October 29, 2021

Subject: Phillips Short Plat/File No. SUB21-004
Response to 06-22-2021 Incomplete Application Comments

PED Project #20014

# 1 TREE REPLACEMENT PLAN

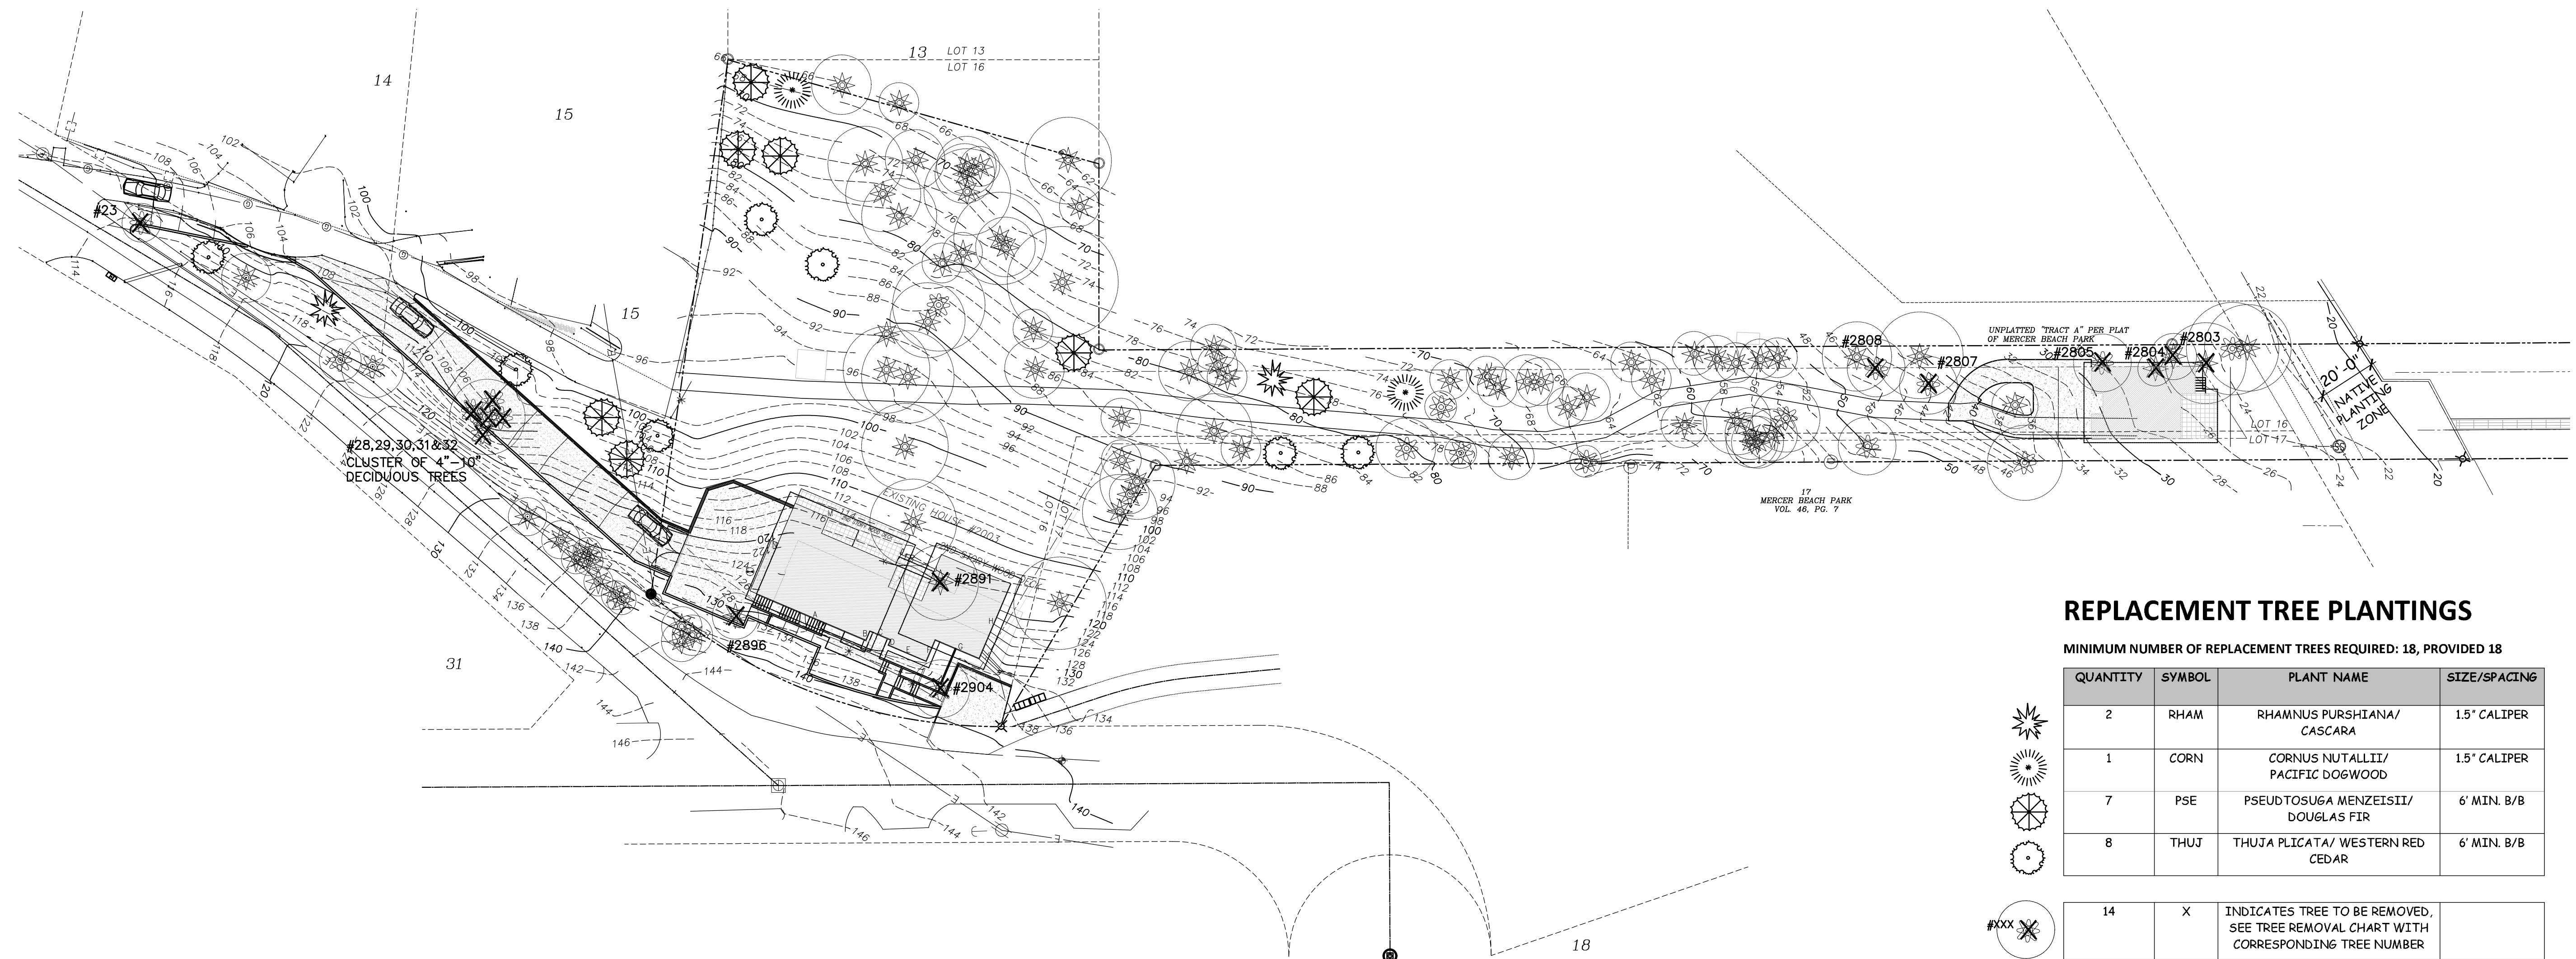
7. *Please provide a tree retention and replanting plan in the development plan set. Please see the attached tree review checklist for more information about needs to be added to the plan set.*

Response: see tree inventory plan included in the Pacific Engineering plan set.
